SITE PLAN

13 VAN VECHTEN STREET
 PORTLAND, MAINE

HIGGINS LOT 3

P-1

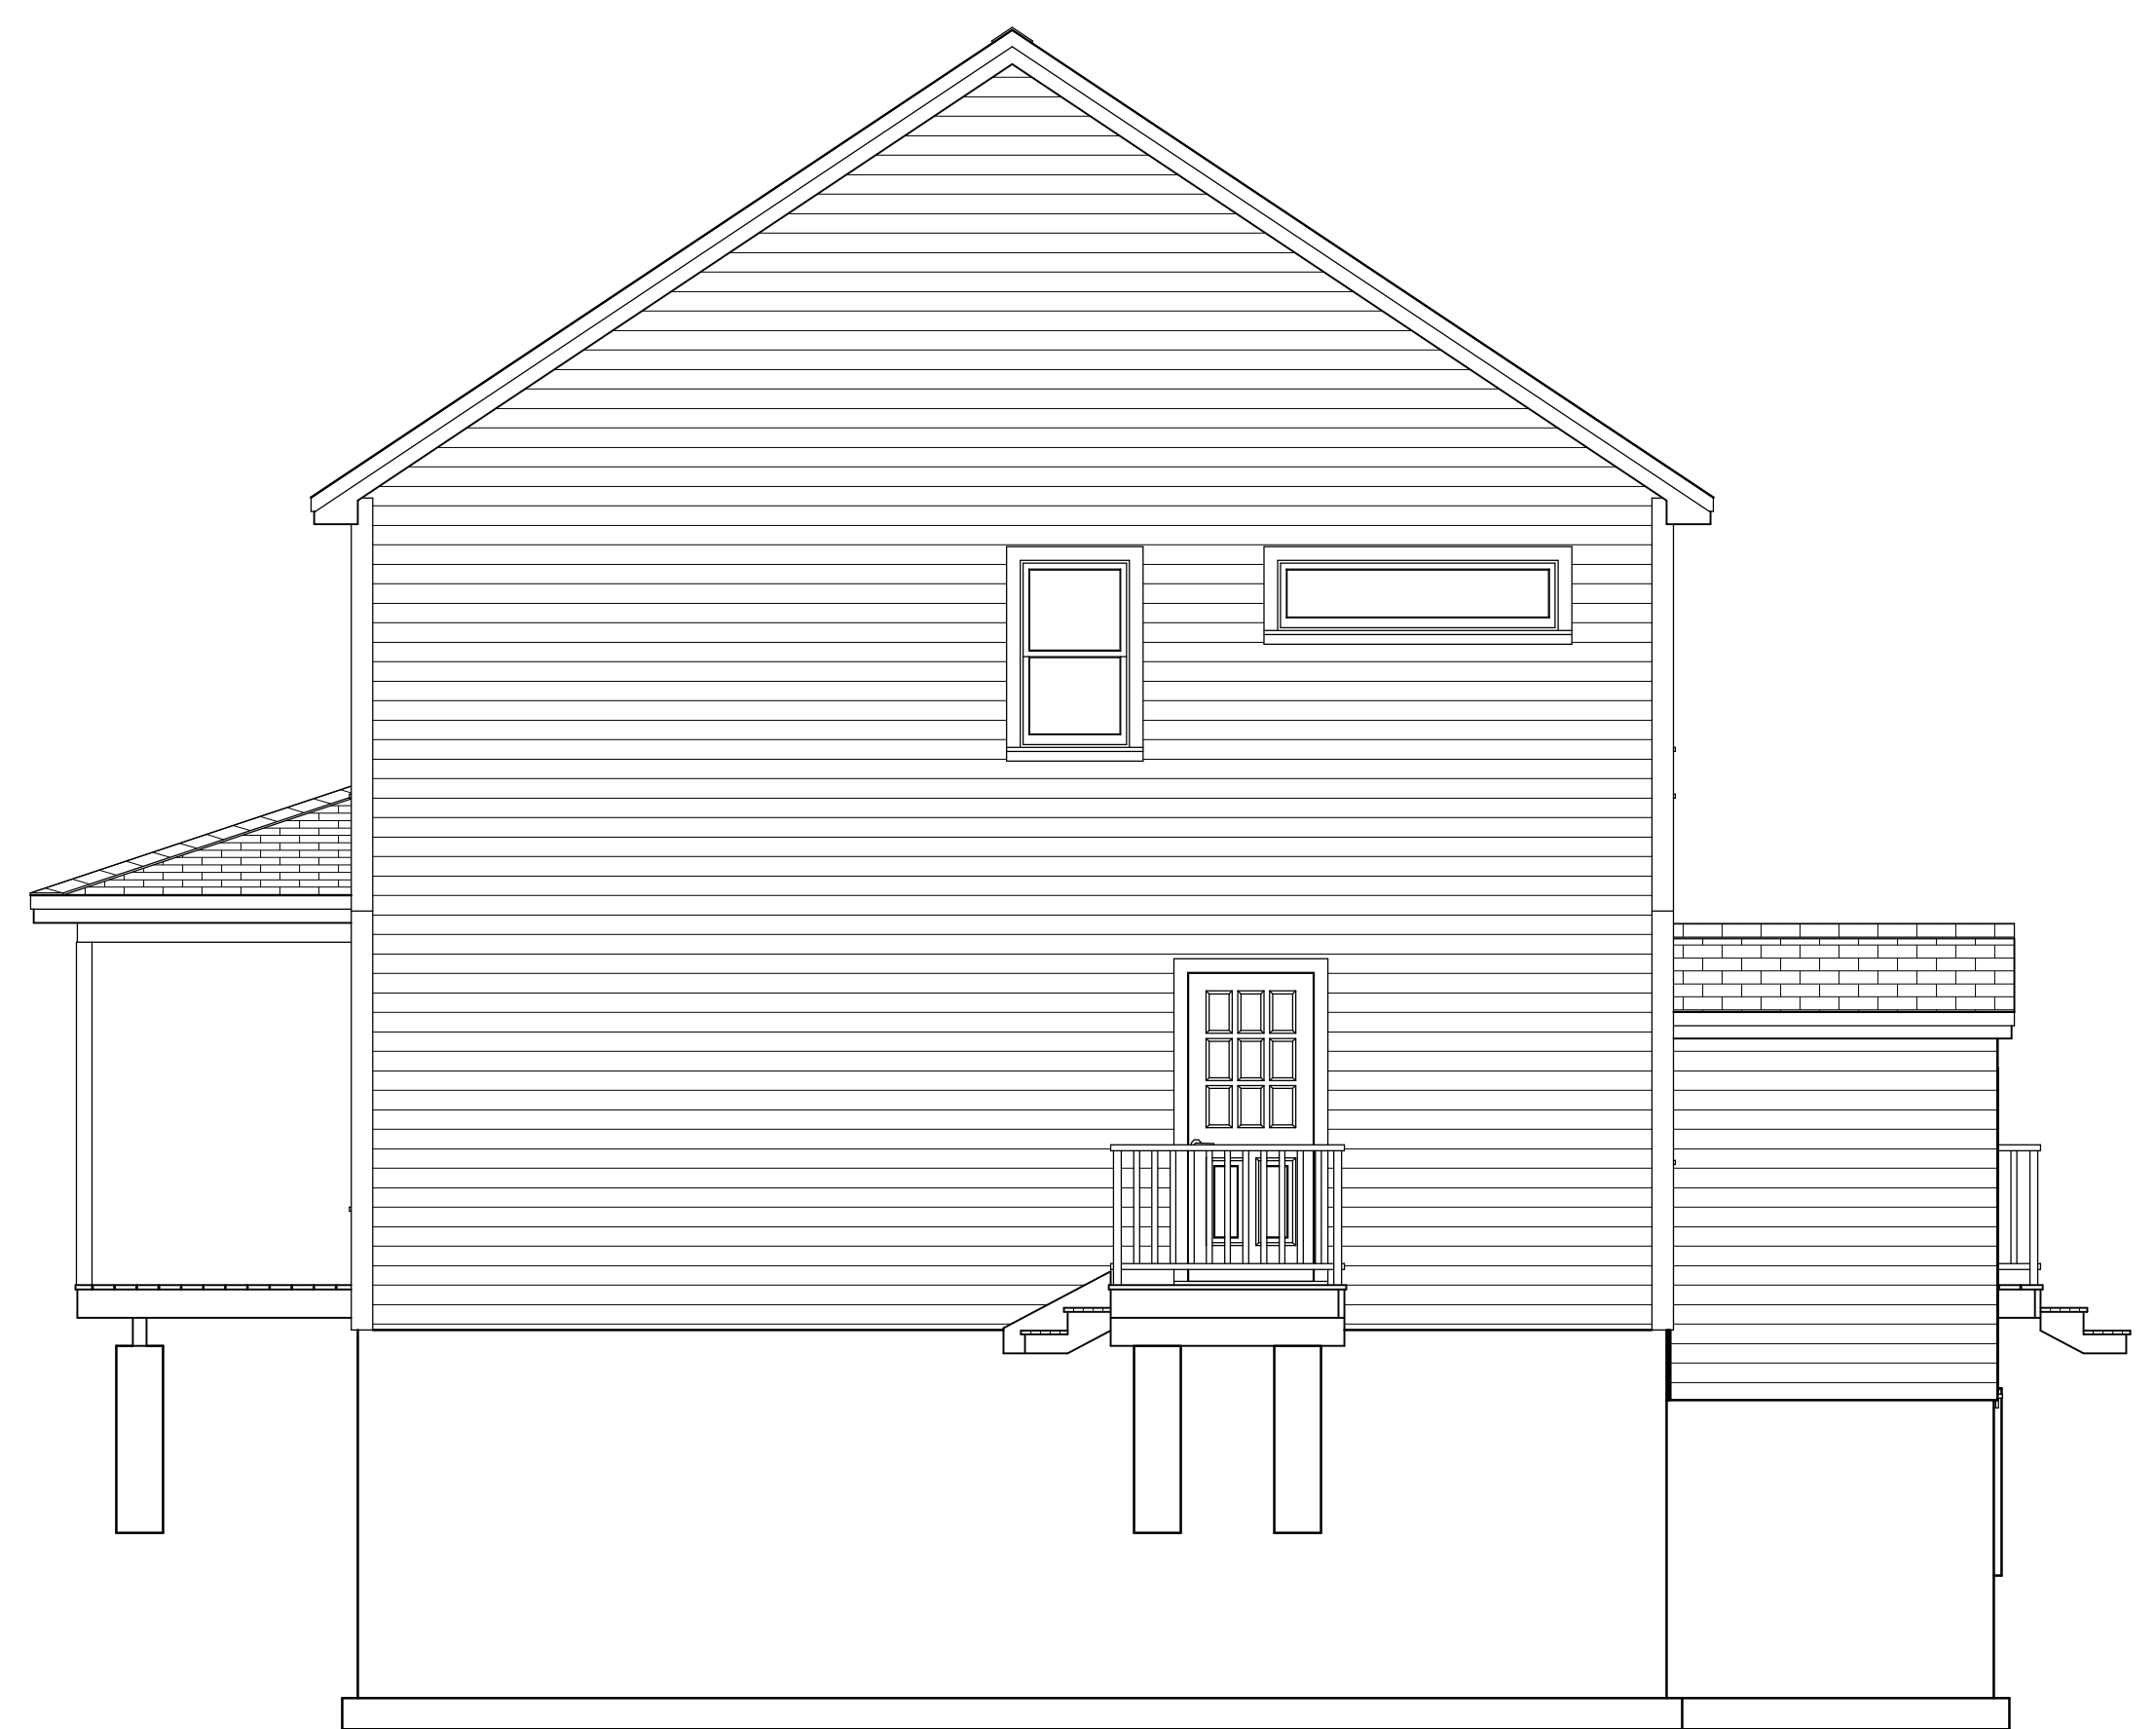
Please add a note
about the sprinkler
installation

SHEET:
 P-2

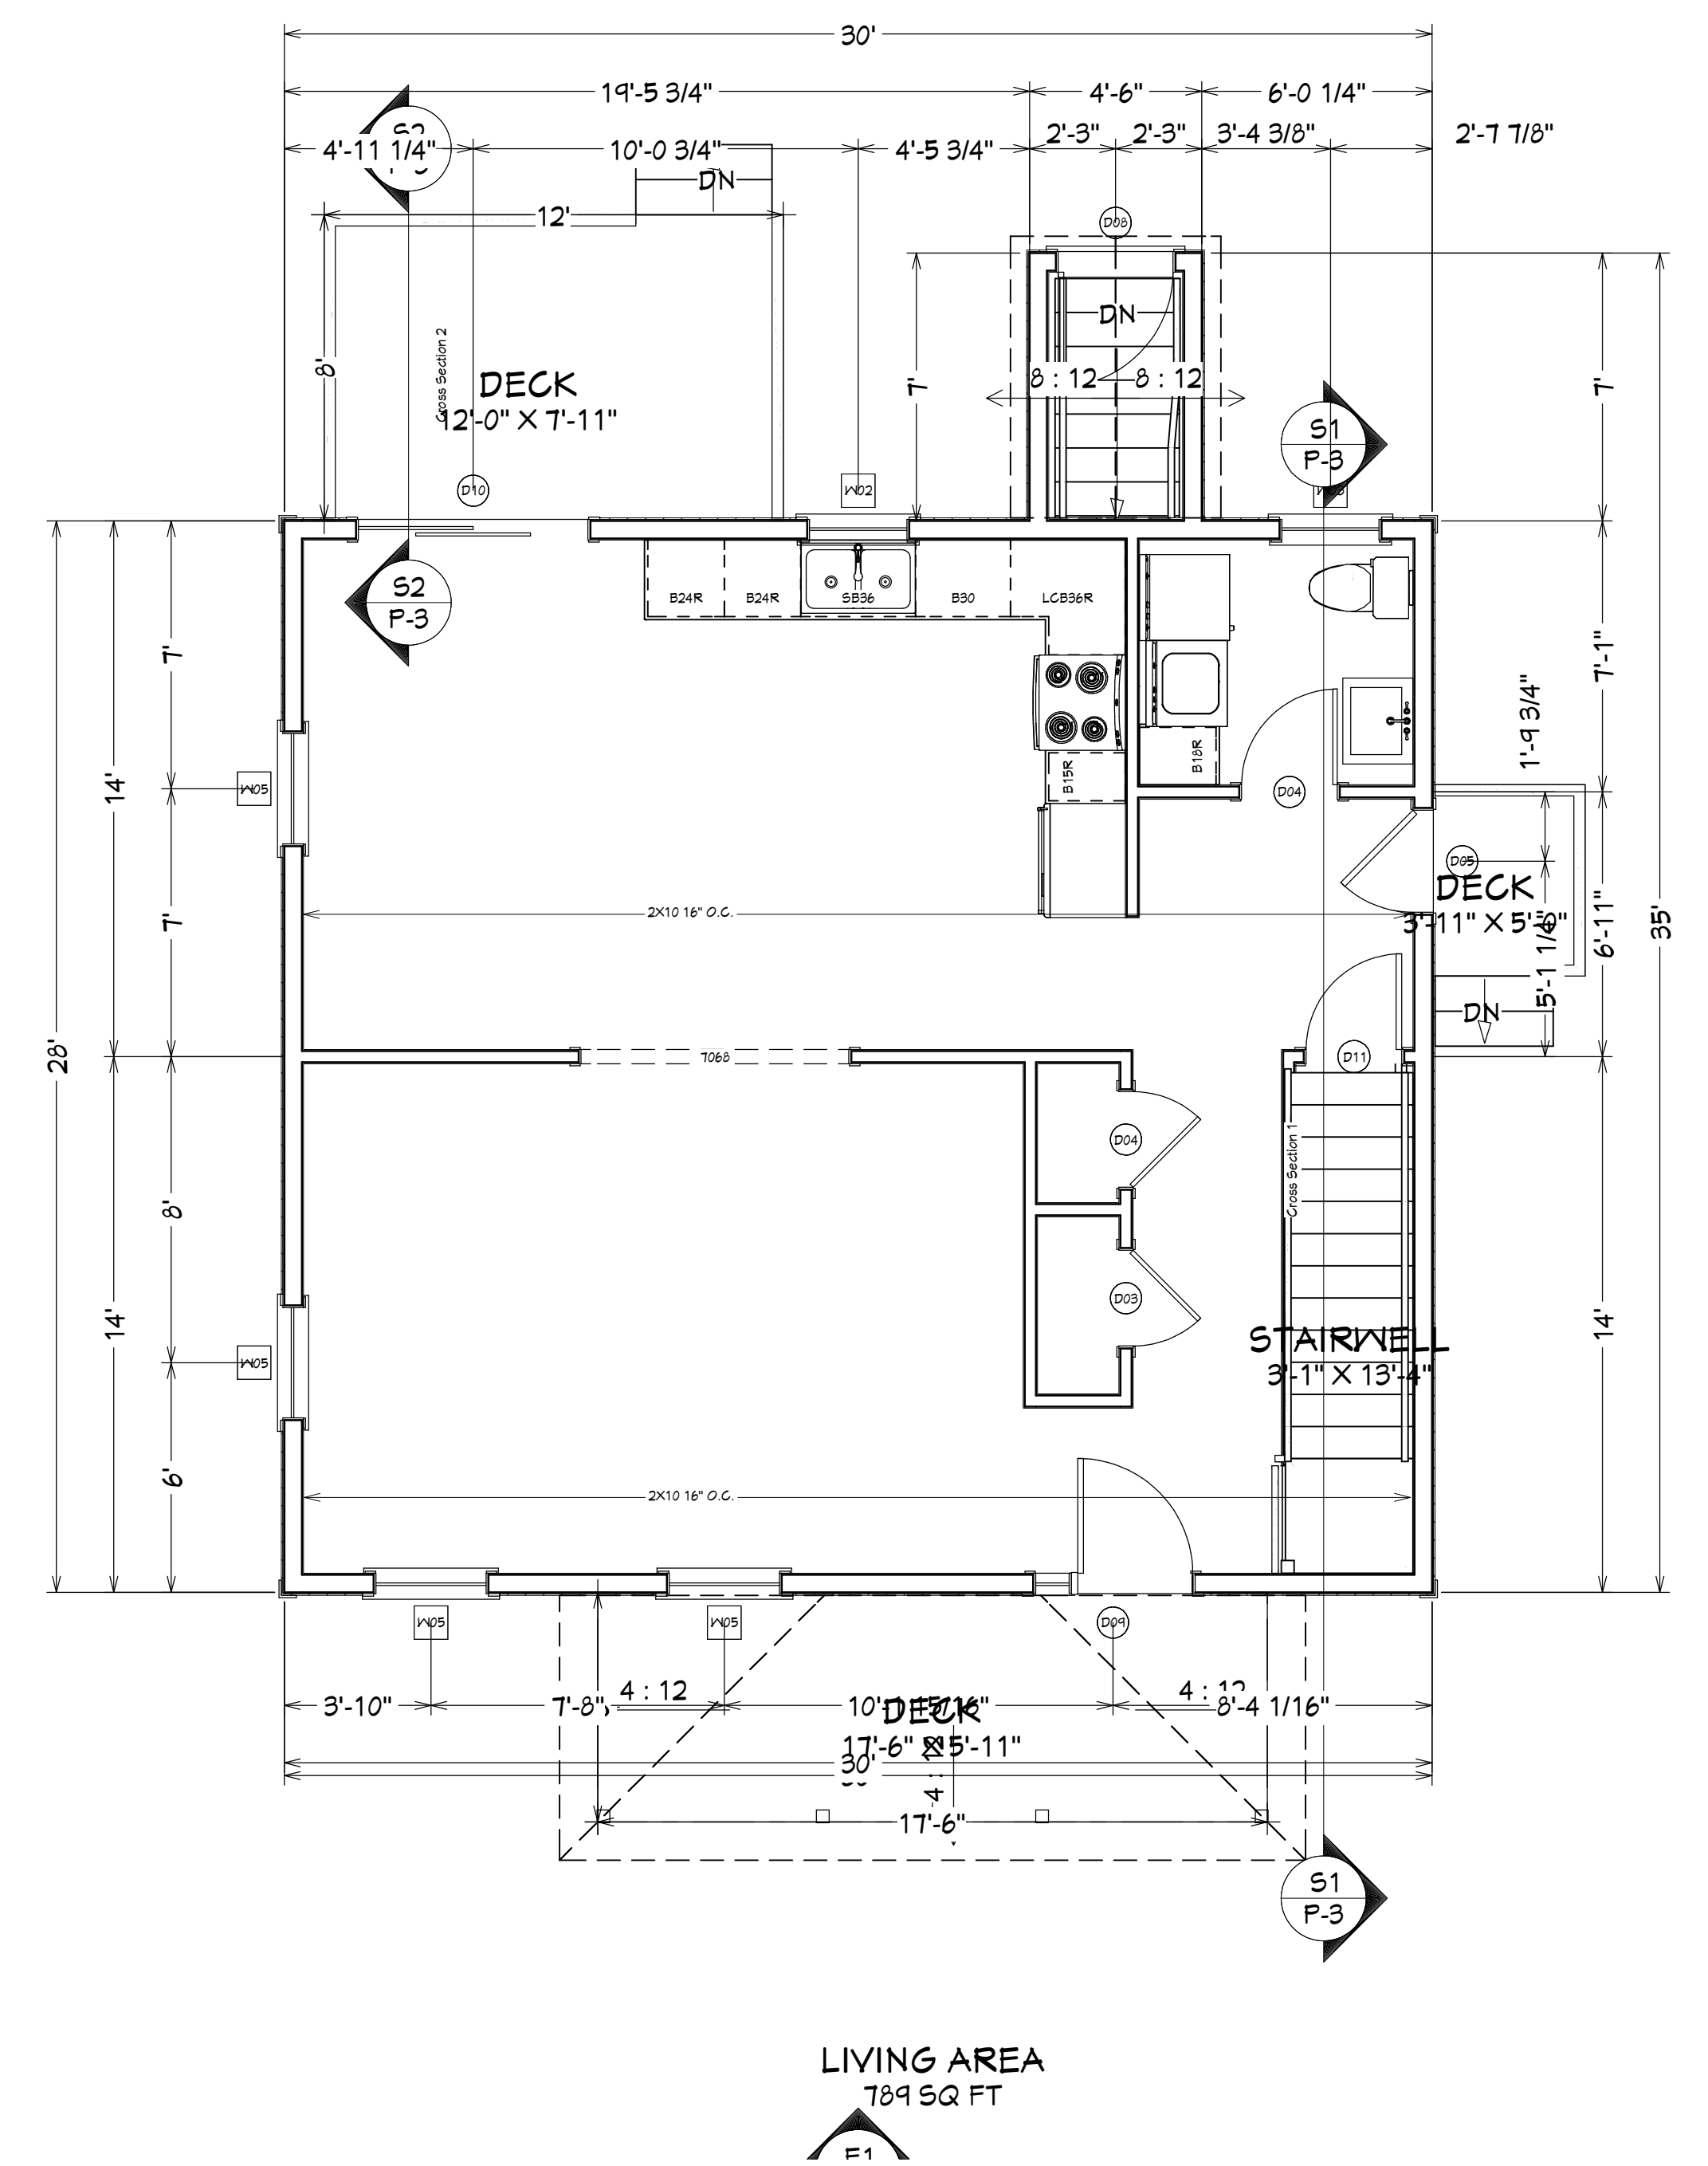
Please provide a Door Schedule

Please provide the location of the attic scuttle, dimensions, door R-value, and if using blown in cellulose, how it will comply with IECC Sec. 402.2.3
